TOWN AND COUNTRY PLANNING ACT 1990 NON MATERIAL AMENDMENT

Reference: H08-1031-25 **Date of Decision:** 31st October 2025
Applicant: R K Wilson Builders Ltd.
C/O Robert Doughty Consultancy Limited
32 High Street
Helpringham
Sleaford
NG34 0RA
Location: Riseholme Farm Windmill Lane Gosberton Risegate Spalding
Description: Erection of 6 single storey dwellings and garages, formation of parking and bin collection point and reinstatement of existing access - approved under H08-0282-24. Amendments to foundation design to that required under Condition 3 of approval H08-0282-24

South Holland District Council hereby give notice that this application has been REFUSED in respect of the non-material amendments referred to above for the following reason(s):

TITLE
PROPOSED STRIP FOUNDATION ARRANGEMENT
& SECTIONS – PLOT 5

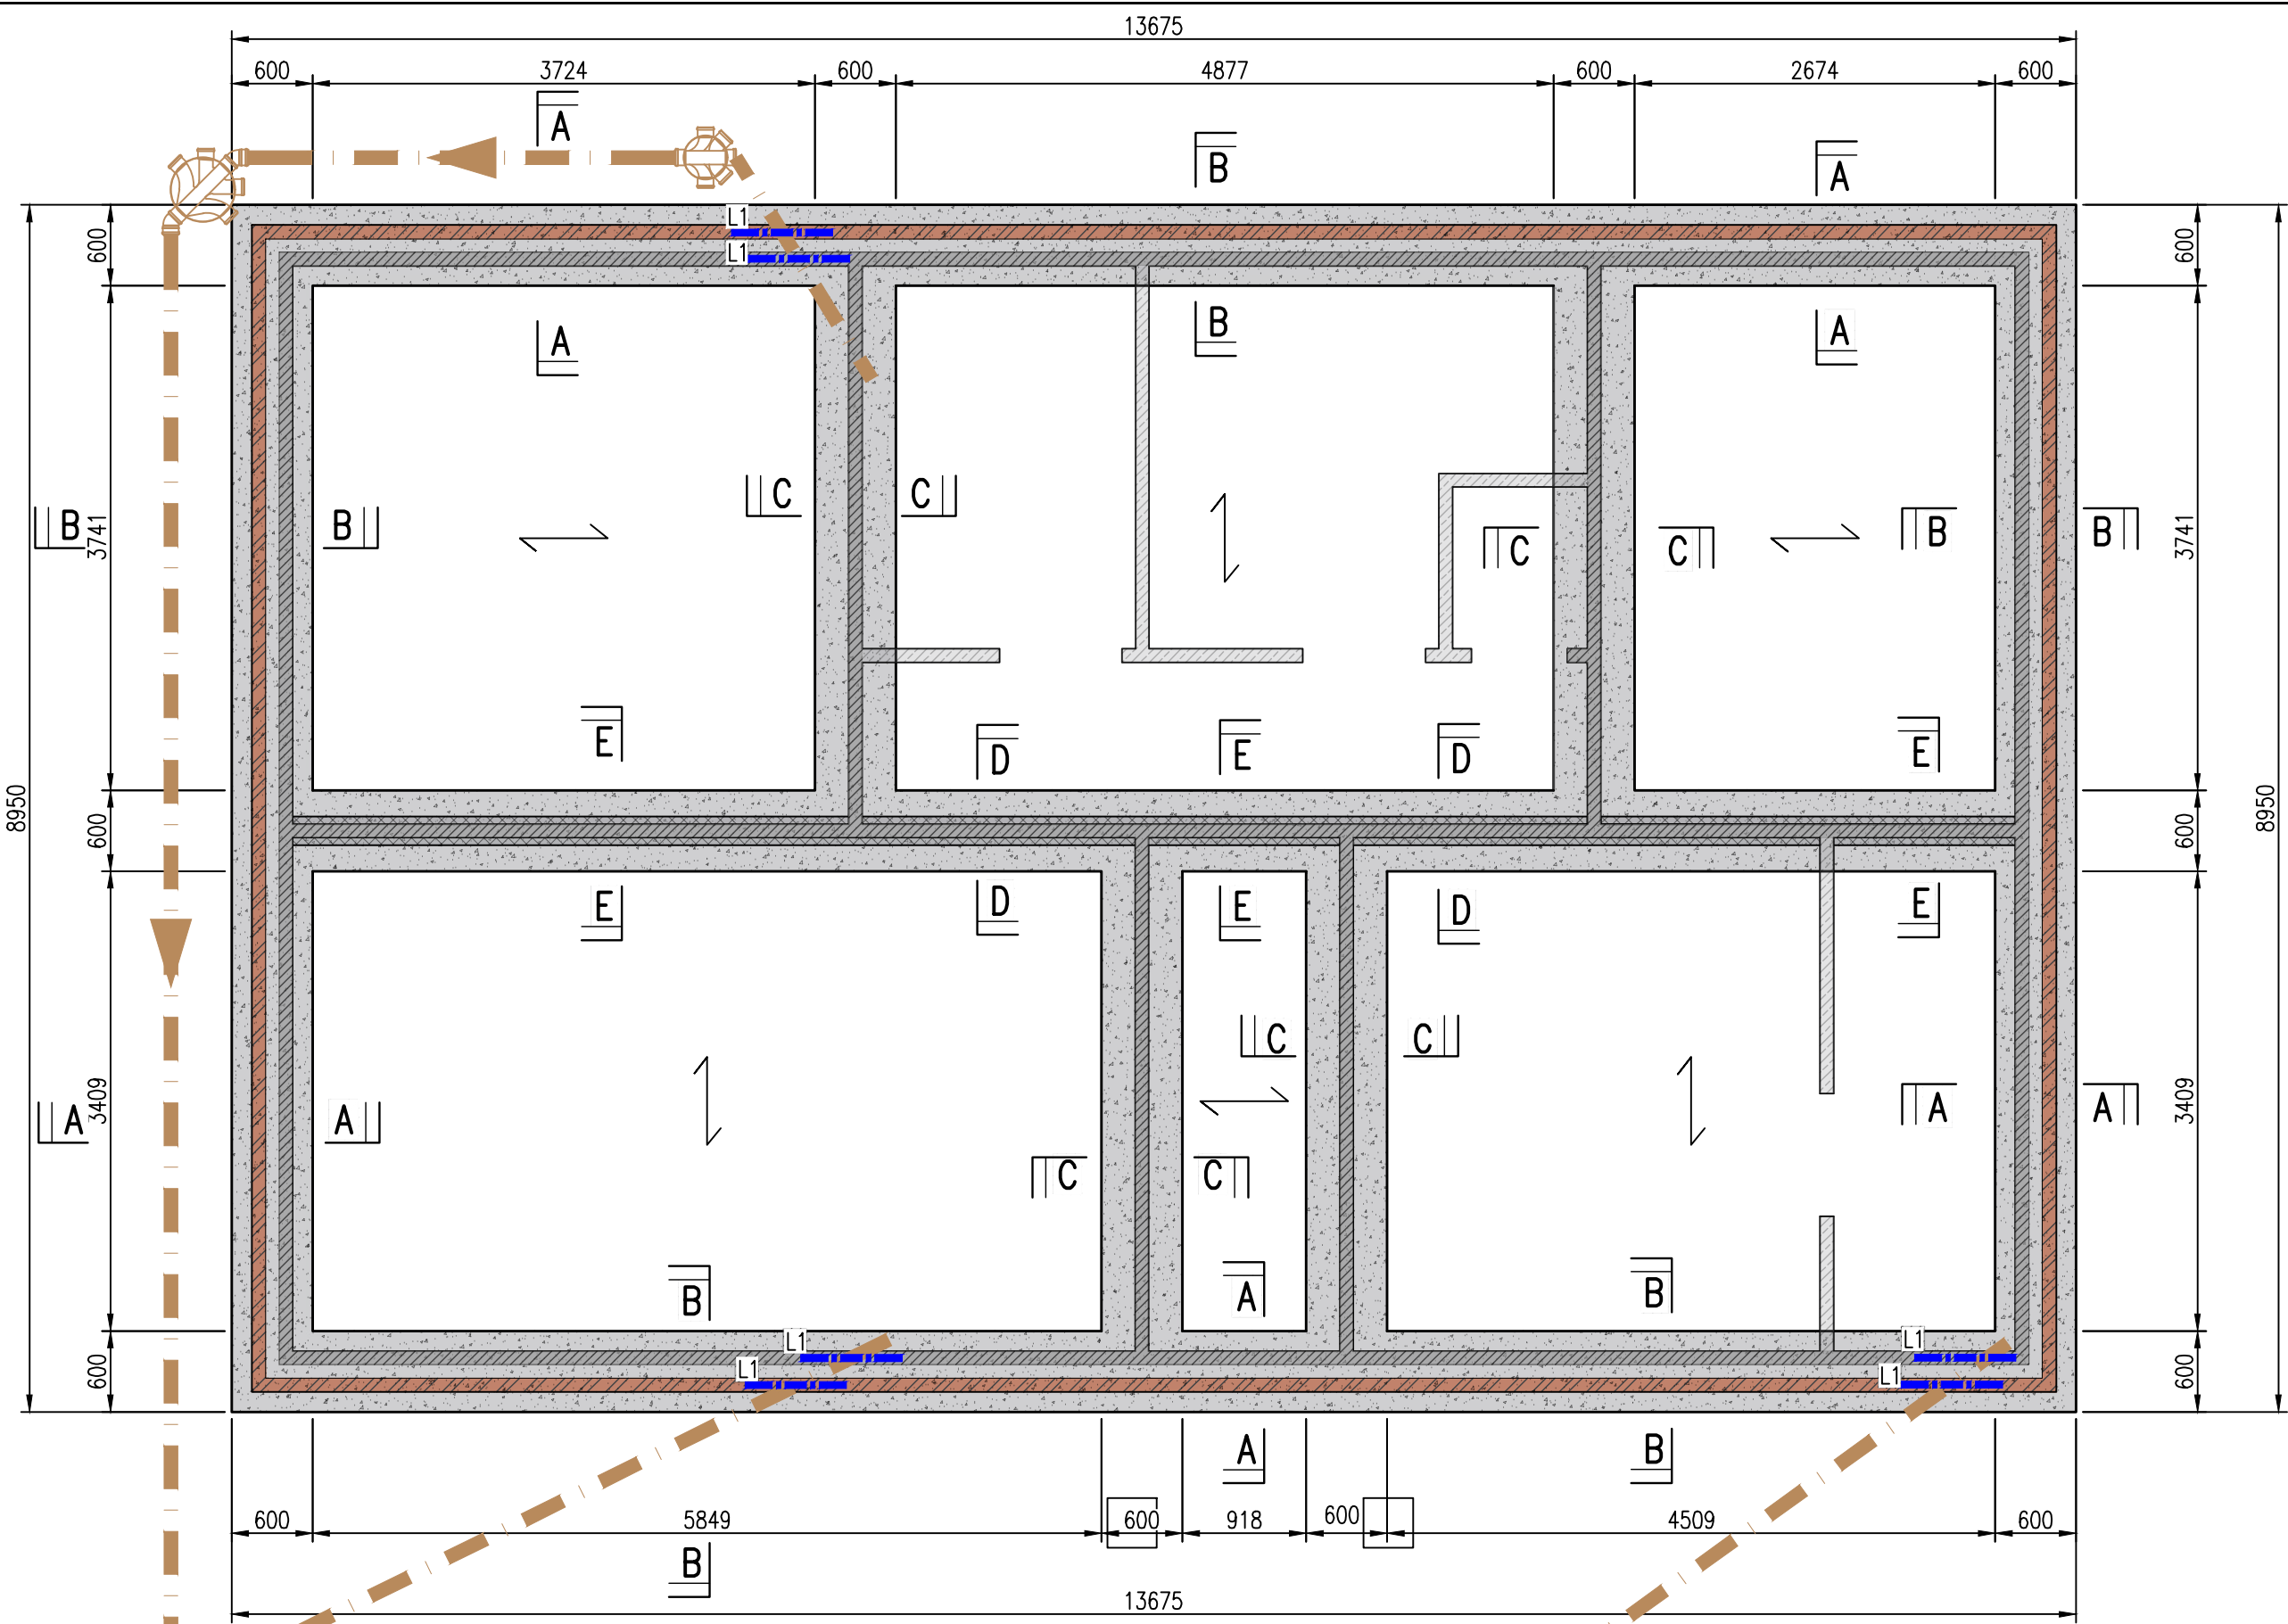
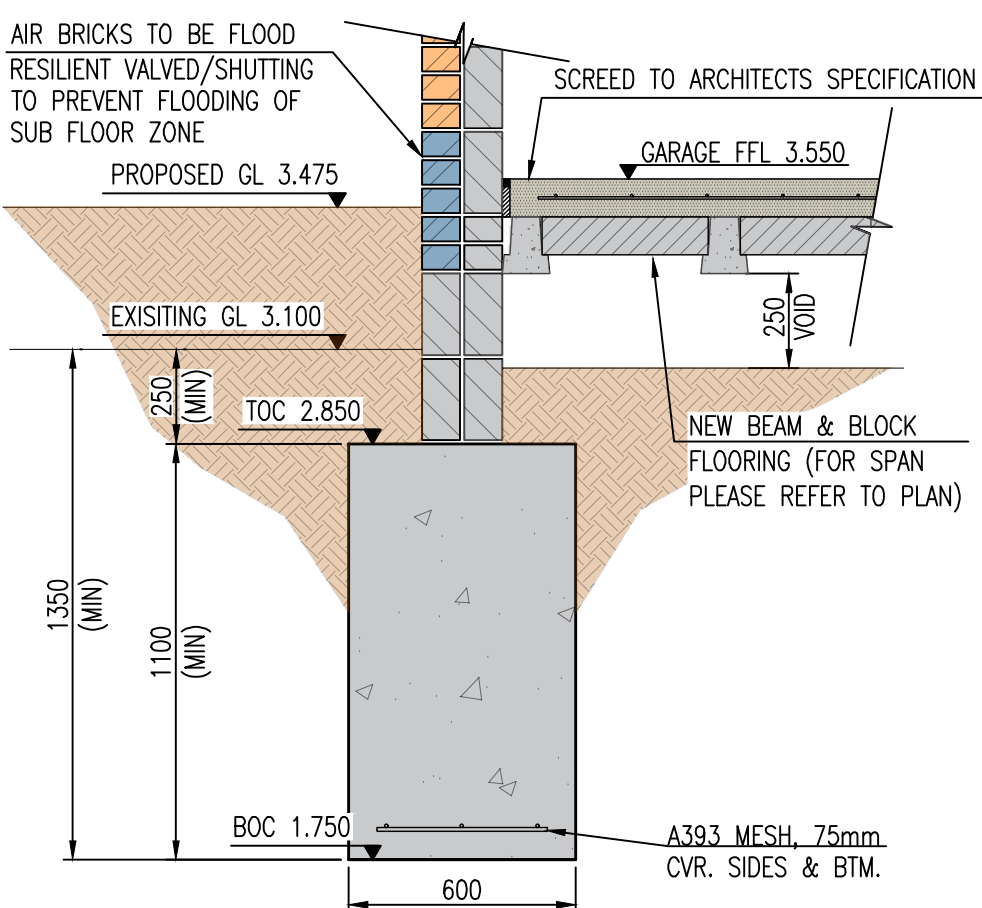
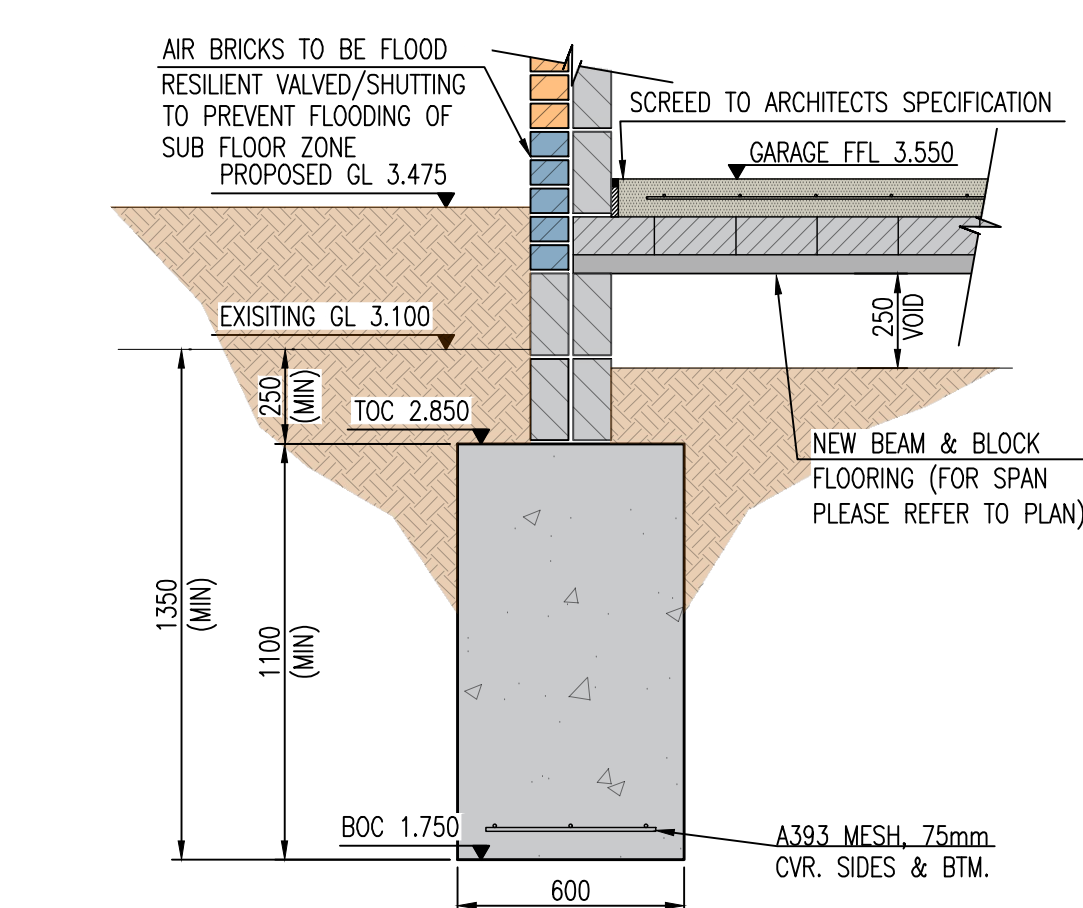
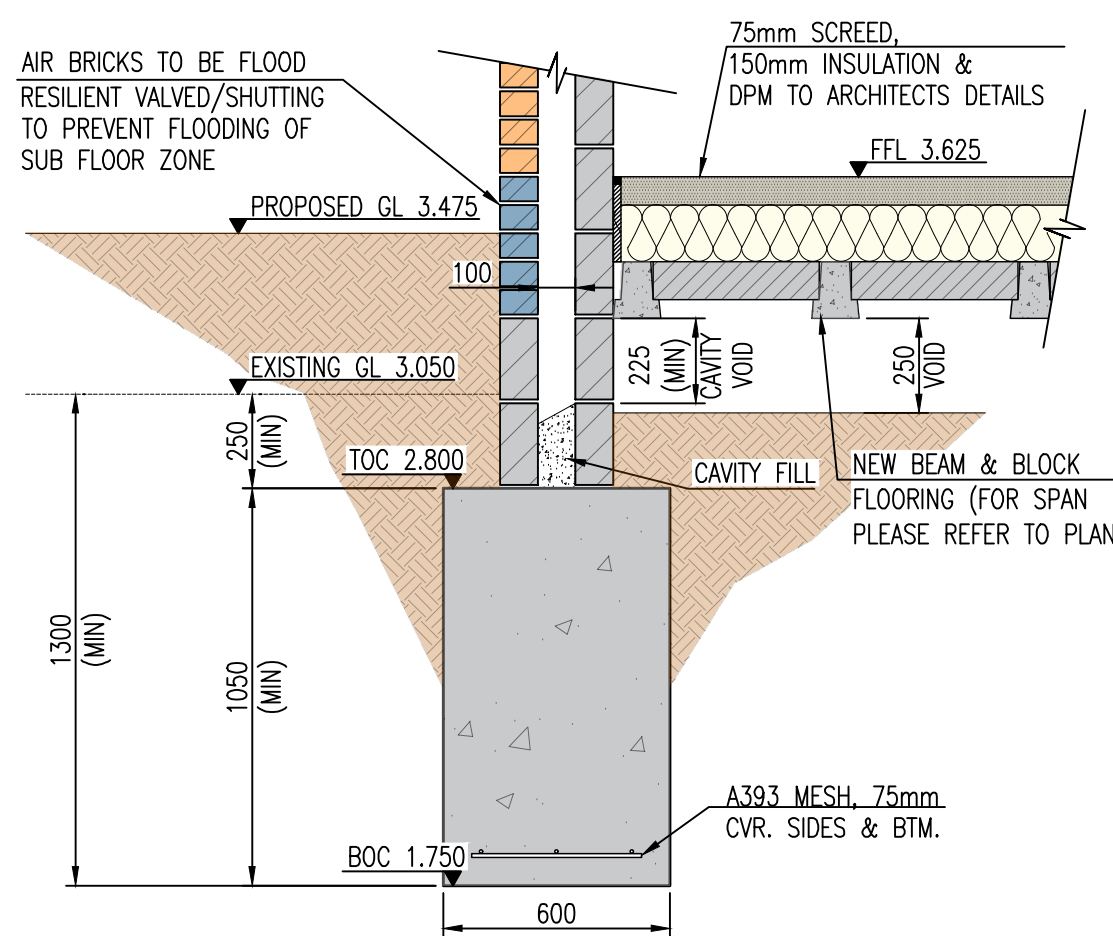
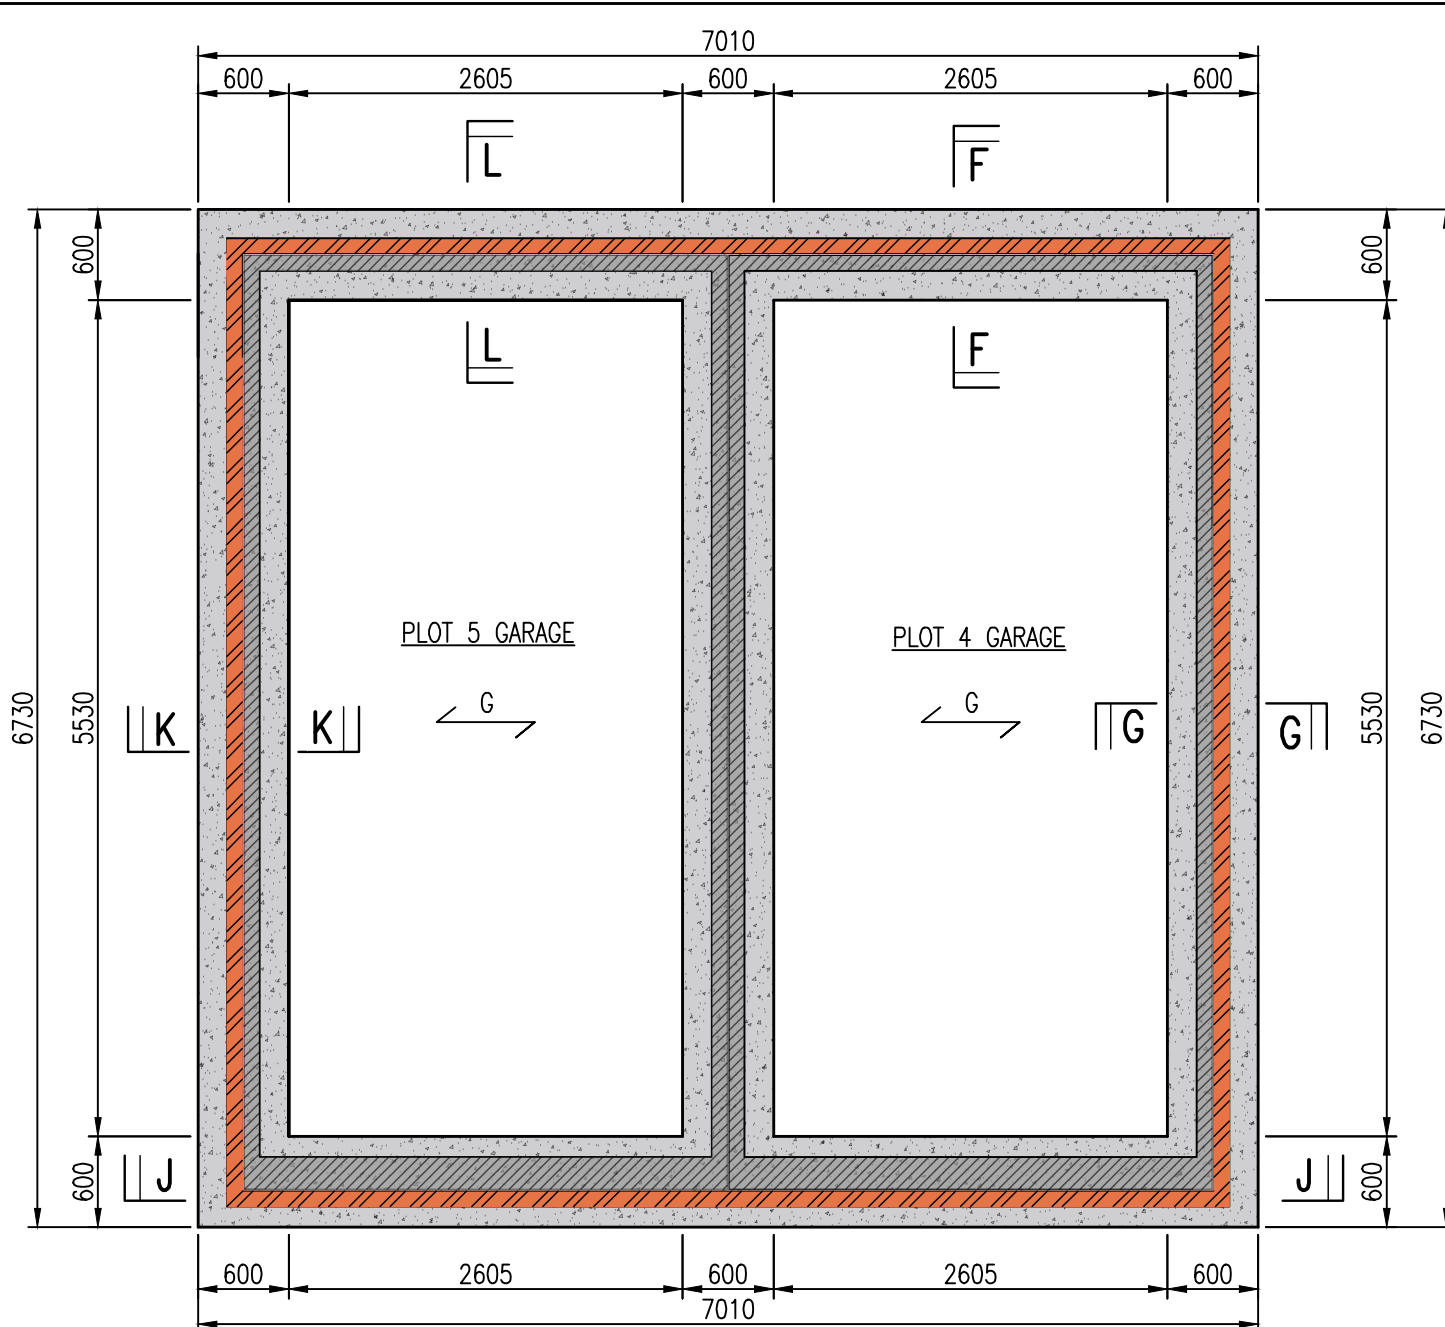
- 1 Point 8 of South Holland District Council's guidance on non-material amendments confirms that such amendments must not result in a fundamental change to the design of the approved building. The approved Flood Risk Assessment (FRA) by RM Associates establishes a critical flood resilience requirement that "the ground floor shall be constructed with a solid concrete floor with no voids beneath and no low-level wall vents." The proposed introduction of a strip foundation incorporating voids beneath the floor would fundamentally alter this key element of the approved design and directly conflict with the flood mitigation measures integral to the scheme's acceptability.

Accordingly, the amendment would constitute a material change to the approved development and cannot be treated as a non-material amendment under Section 96A of the Town and Country Planning Act 1990 (as amended).
